From: Paul Cann <Paul.Cann@arun.gov.uk>
Sent: 09 October 2020 13:25
To: Planning.Responses <Planning.Responses@arun.gov.uk>
Subject: RE: Planning Consultation on: AL/64/20/PL

Comments on surface water drainage;

Application No: AL/64/20/PL
Registered: 28th August 2020
Site Address: Springfield Hook Lane Aldingbourne PO20 3TE
Grid Reference: 493480 104546
Description of Works: Demolition of the existing dwelling & construction of 2 no. 2-bed. 3 no. 3-bed, 4 no. 4-bed houses including access, landscaping & associated works (resubmission following AL/27/20/PL)..

Drainage Strategy				Draining The
Engineering Details				
Drawn	Checked	Scales	Paper Size	Date
JN		1:250	A1	08.19
Job No.				Revision
KNC/1932	602-01			C

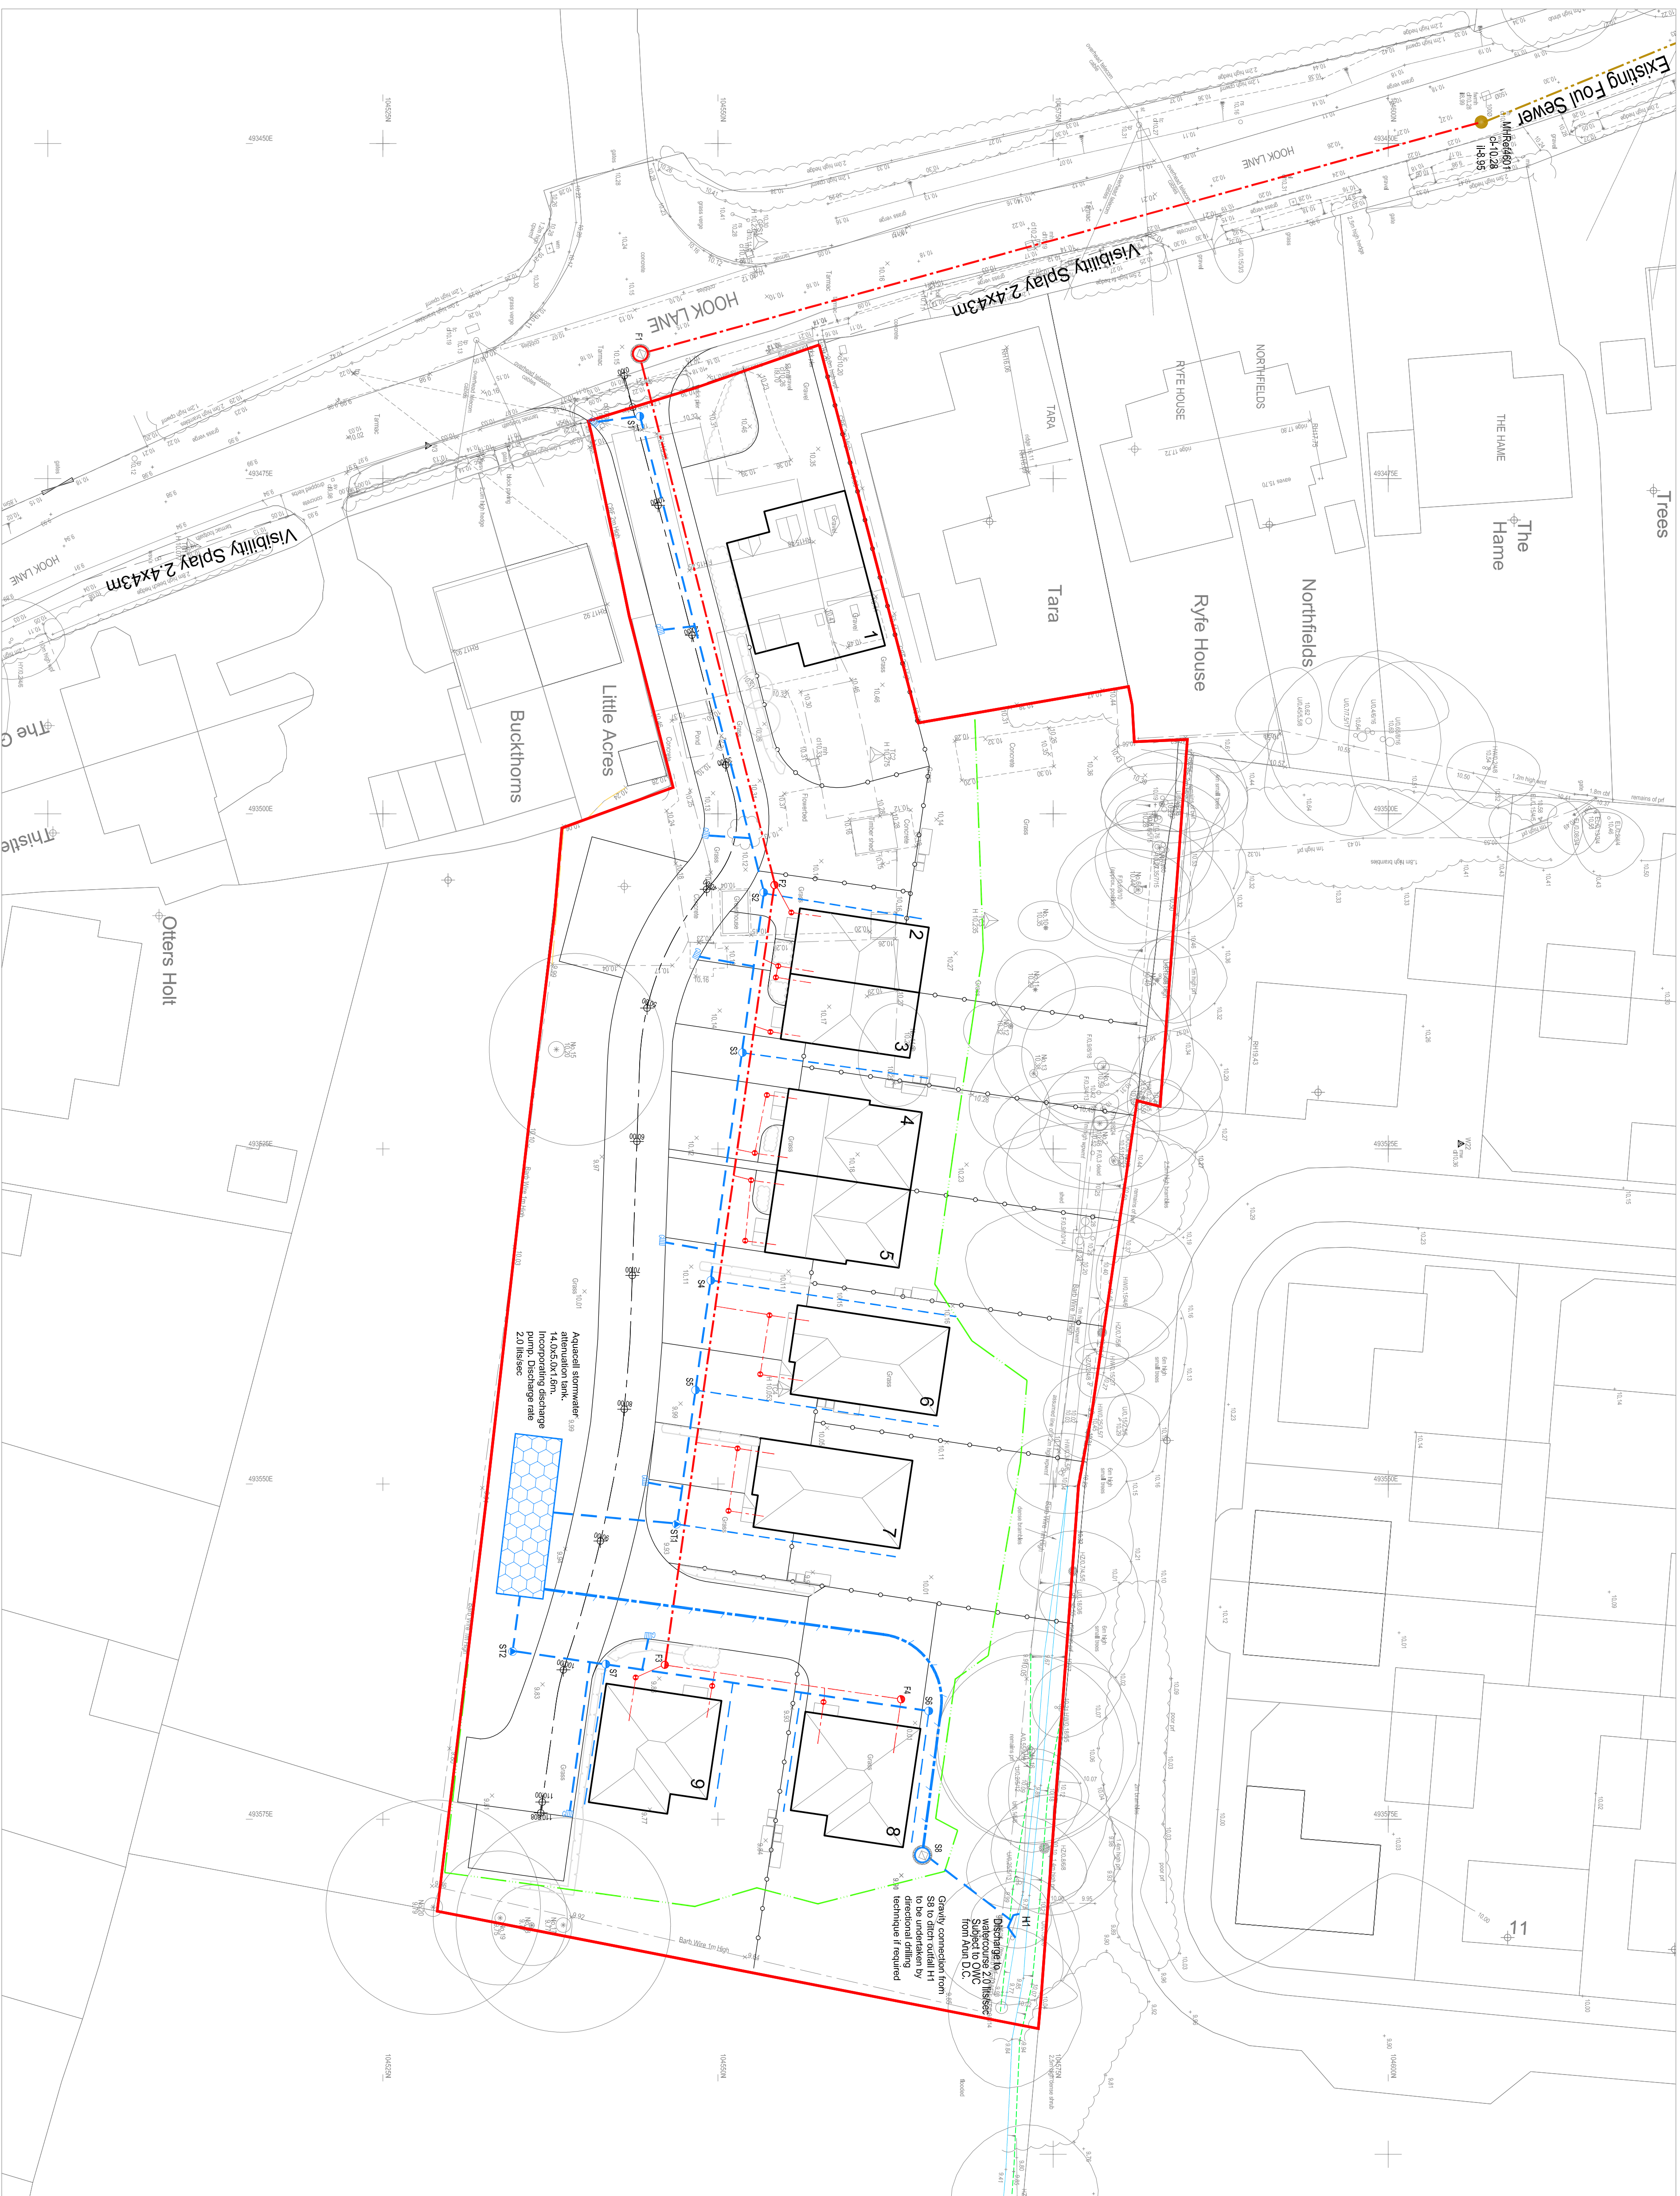
Our comments and request for conditions as per the previous application (AL/27/20/PL) still stand. These are enclosed for ease of reference. As previously stated, pumping is not sustainable and gravity options must be fully explored. To address this, the applicant should consider the significant use of permeable paving and other shallow features to convey and store water across the site, whilst minimising the use of pipework.

It should also be noted that Barratt David Wilson (BDW) have recently undertaken works to the boundary ditch and installed a positive outfall from it into their onsite drainage system. The applicant should fully survey the ditch and its outfall, as this will impact any design. It may be necessary for the applicant to undertake further works to this ditch in order to reduce bed levels where possible, in order to aid a gravity solution.

I confirm that the current conflict between the drainage scheme and the existing trees, which needs to be resolved and I acknowledge the tree officers current objection. It should be noted that whilst a connection to the watercourse will be required, its precise details are subject to change during detailed design.

The development layout appears not to address our previous mentioned requirement of ensuring boundary fences are kept at least 3 metres away from the bank of the northern boundary ditch in order to allow maintenance, etc. It

is suggested that the true extent of the ditch is clearly indicated on the drawings and resurveyed to take account of the works undertaken by BDW. This matter must be resolved before the layout is agreed.
